From: Simon Davis
Sent: 04 September 2013 15:21
To: 'richard lowe'
Cc: Charlotte Hardy
Subject: RE: BR/201/13/DOC - 3 Marine Drive West, Bognor Regis

4.2 SOLAR PHOTOVOLTAICS (PV)

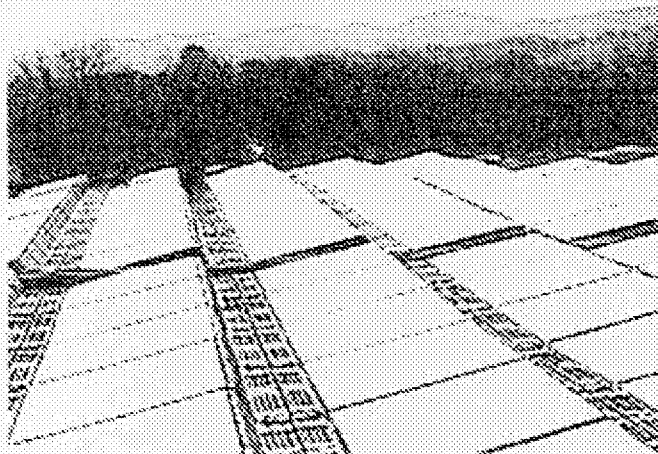
On a more personal note I feel that the option of solar water heating or PVs have discounted too easily. I feel that something potentially combining the two may create more guaranteed savings. Potentially this may be done through them being applied to only the number that are feasible (such as the top 2 flats specifically or 2/3 floors)."

4.3 AIR SOURCE HEAT PUMPS (ASHP)

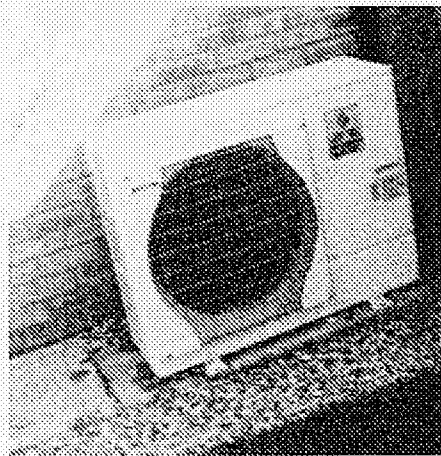
I have looked at the specification for the ASHP which they have proposed might be used (Kingspan Aeromax plus) and I am confused as to whether the energy calculation has taken into account the electricity that will be required to operate the ASHP as part of the calculations (as it is not clear in the report). If they are planning to install a radiant system in those two flats (which requires 55-70 degrees heat input) rather than a underfloor heating system (which would operate on a much lower input temperature of around 35 degrees), then the coefficient provided by Kingspan on the expected efficiency of the systems for these flats is significantly lower at just over 2:1 rather than the optimum rating of 3:1-4:1. This would mean the end user would only get 2 units of renewable heat out for every 1 unit of electric put in rather than 3 or 4.

To make a real comment on this I think we would need to know what coefficient the developers were working to when specifying these ASHPs to see how realistic they are actually being and because of the typo, we would need clarification on what type of heating system will be installed in those two flats as mentioned above.
